Your Ref: OWPC21650
Our Ref: R/15/19/HH 25-01-2019
Please ask for:
Zac Denton

Convert existing garage to habitable space, new oriel window replacing existing, render to existing brick frontage & part side walls & replacement of flat roof with pitched tiled roof.

28 The Crescent Rustington

Project: 28 THE CRESCENT, RUSTINGTON, BN16 2PF
Drawing: PROPOSED ELEVATIONS
Scale: 1:100 1 2 3 4 5 M
Date: JAN 2019 Drawn: MT No: 1911-P-05 Rev: A

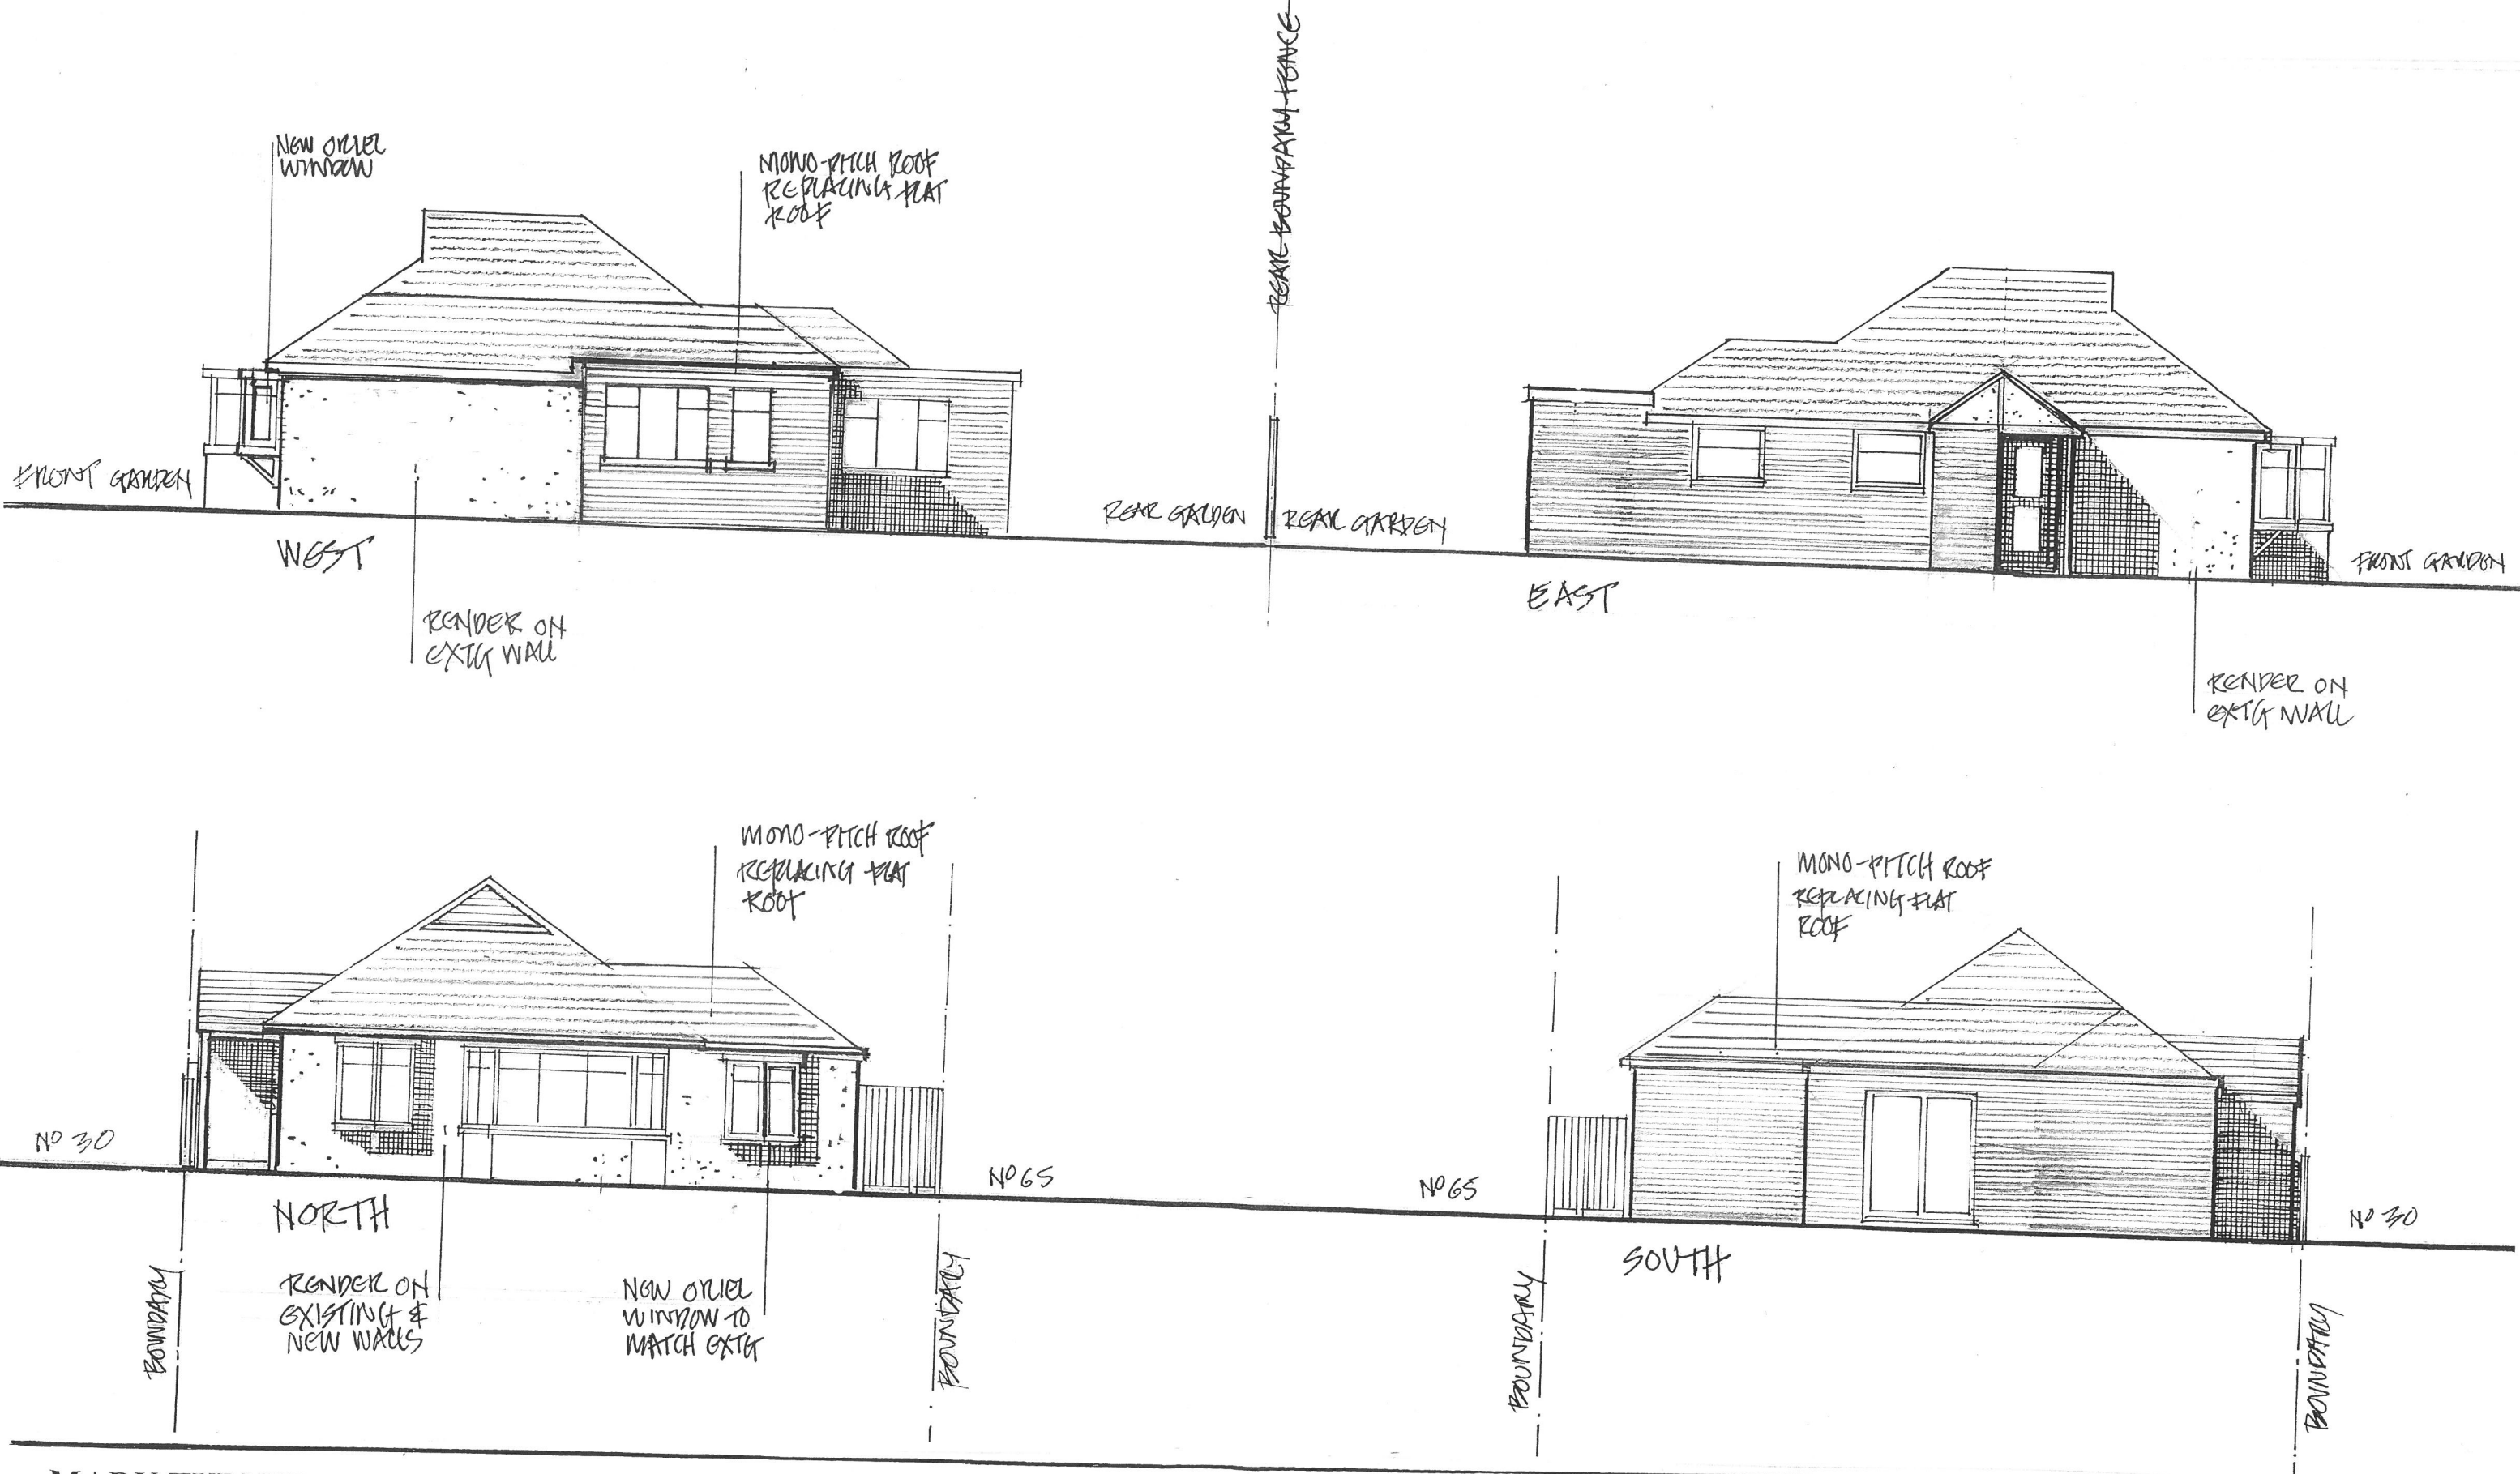
The existing elevation plans(east&north)show a porch with a pitched roof where in fact it's a recently built porch with a Flat roof. It has already been built up to the boundary of no 30. I am concerned that the proposed pitched roof plans ((east&north) Re the porch do not allow for the pitched roof tile over hang , I am also concerned of possible future water damage to no 30 .
